OEH – Report on Site Verification Certificate

SVC Application No. 14_6526

Project Name : Addendum to Warkworth Continuation 2014

OEH INTERIM ASSESSMENT OF BSAL SITE VERIFICATION CERTIFICATE APPLICATION

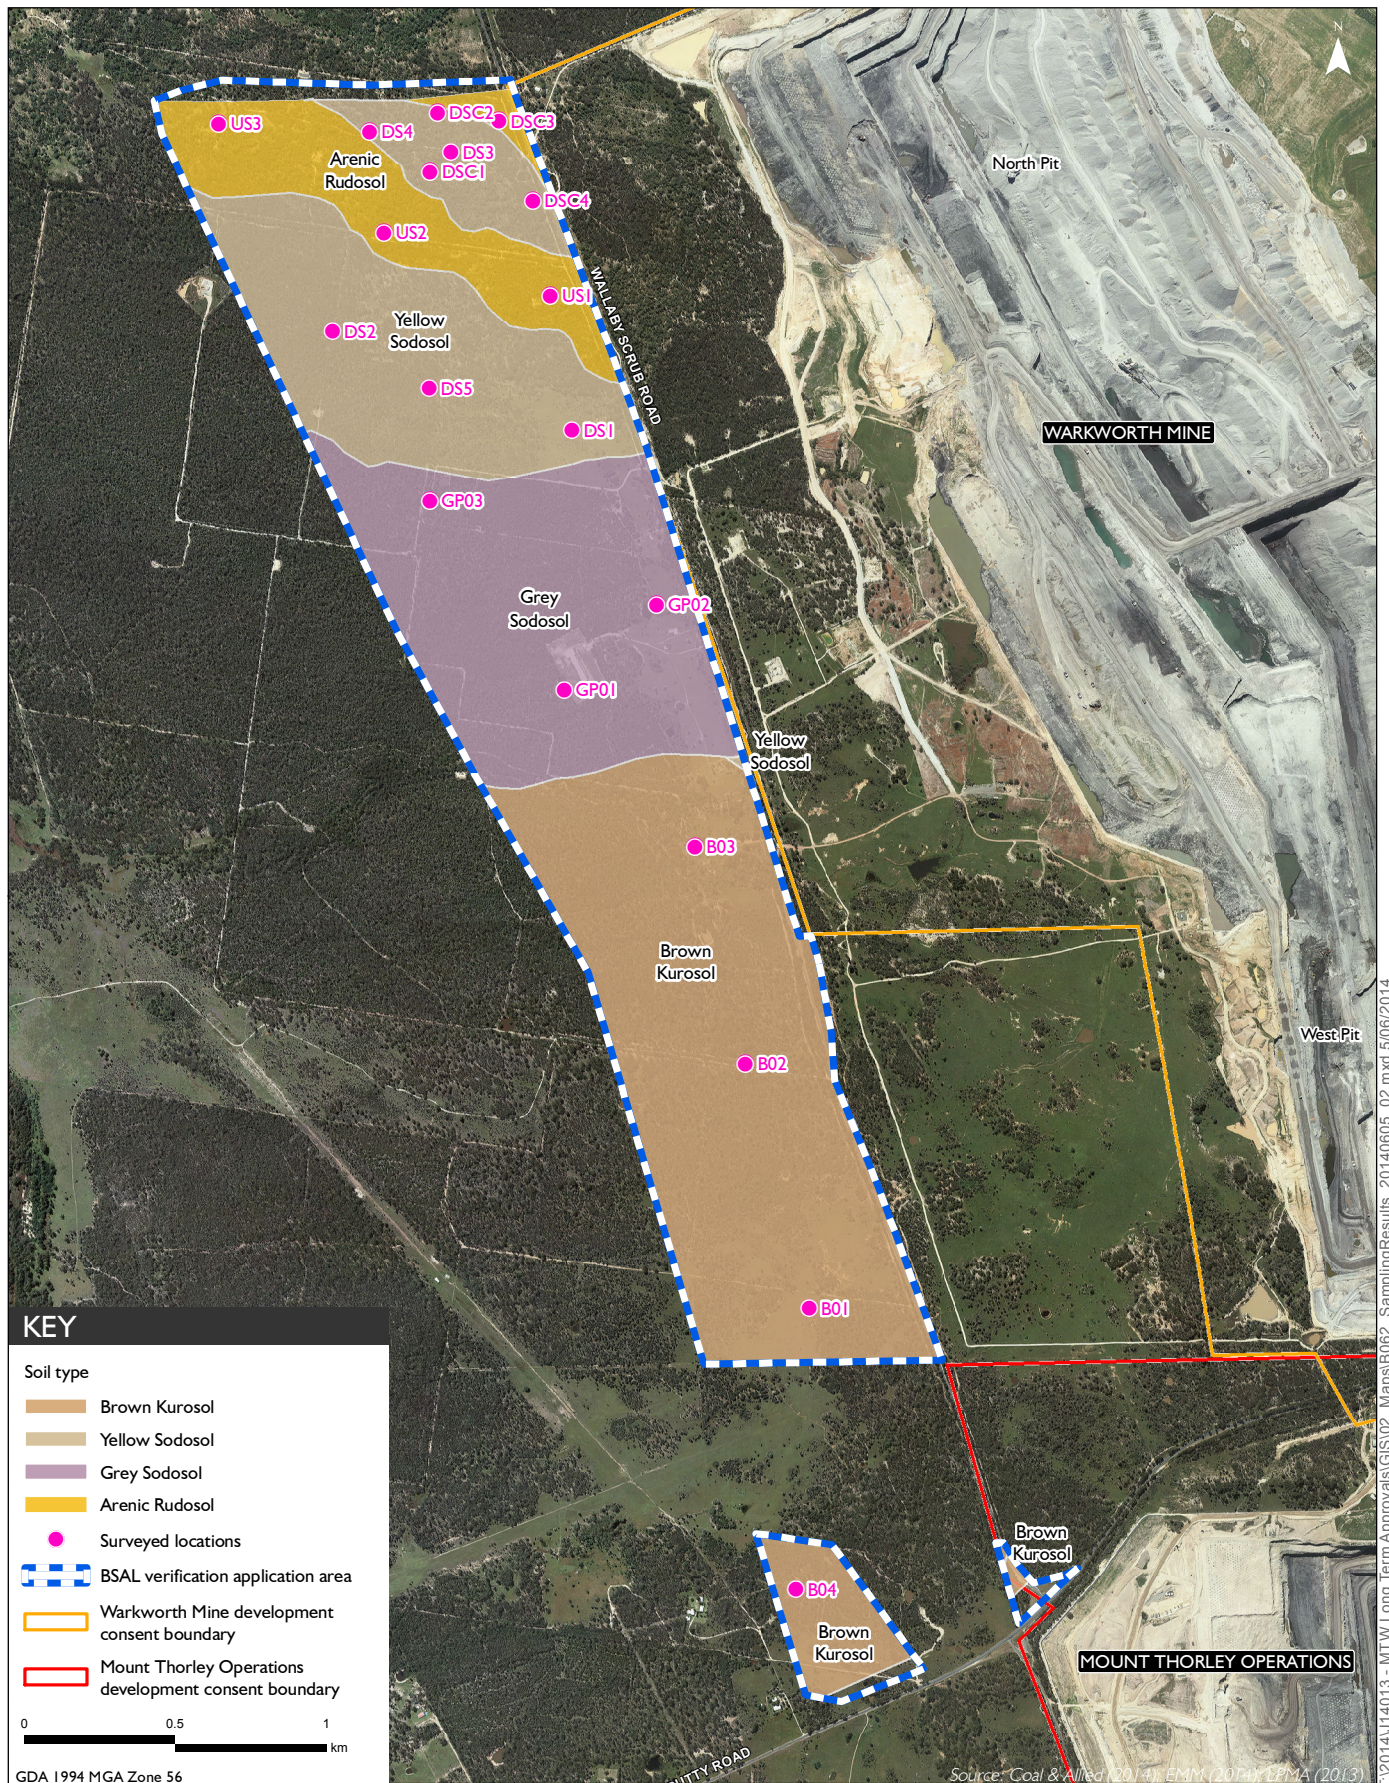
SUMMARY OF ASSESSED ITEMS	Appropriate as per the Protocol		Justification
	Yes	No	
PERSONNEL			
Evidence provided by the applicant that a qualified soil scientist oversaw the verification assessment and signed off on the quality and extent of the work	X		The Addendum report was prepared by Neil Cupples, Senior Soil Scientist at EMM, and oversighted by Dr Timothy Rohde, a Certified Practising Soil Scientist (CPSS, Stage 2) with the Australian Society of Soil Science Inc.
MAPS			
Geographically accurate base map (at 1:25,000) of assessment area supplied as per <i>Interim Protocol</i> . Spatial dataset (boundary of assessment area) supplied in GIS format as per <i>Interim Protocol</i> .	X		Maps and GIS data supplied 10 th June 2014.
Soil map (at 1:25,000) of project area supplied including all observation (Detailed, Check and Exclusion) sites as per <i>Interim Protocol</i> . Spatial datasets (soil map, observation sites and data reliability/data source diagram) supplied in GIS format as per <i>Interim Protocol</i> .	X		Maps and GIS data supplied 10 th June 2014. Check sites DSC1 through DSC4 have confirmed the polygon previously labelled 'Duplex sand' to be 'Arenic Rudosol' (Addendum report, p.9). However, this has not been reflected in either the hard-copy (Figure 4.1, Addendum report, p.11) or GIS versions of the soil map,

SUMMARY OF ASSESSED ITEMS	Appropriate as per the Protocol		Justification
	Yes	No	
			both of which have the polygon in question still classified as 'Yellow Sodosol'. No data source/data reliability diagram, and no evidence that soil map includes >100 m buffer on soil map. Soil map does not include a ~70 m (max) wide strip of land at the N end of the application area.
Map of assessment area showing BSAL (at 1:25,000) and exclusion zones marked according to their BSAL limitation. Spatial dataset (boundary of BSAL areas) supplied in GIS format as per <i>Interim Protocol</i> .	X		BSAL map provided in hard-copy Addendum report, but not as GIS file.
Maps presented in correct datum with appropriate symbology, north points, unambiguous legends, meaningful colour ramps, scale bars, and sampling grid included as per the <i>Interim Protocol</i> .	X		
Metadata for spatial datasets have been provided as per the <i>Interim Protocol</i> .		X	No metadata supplied.
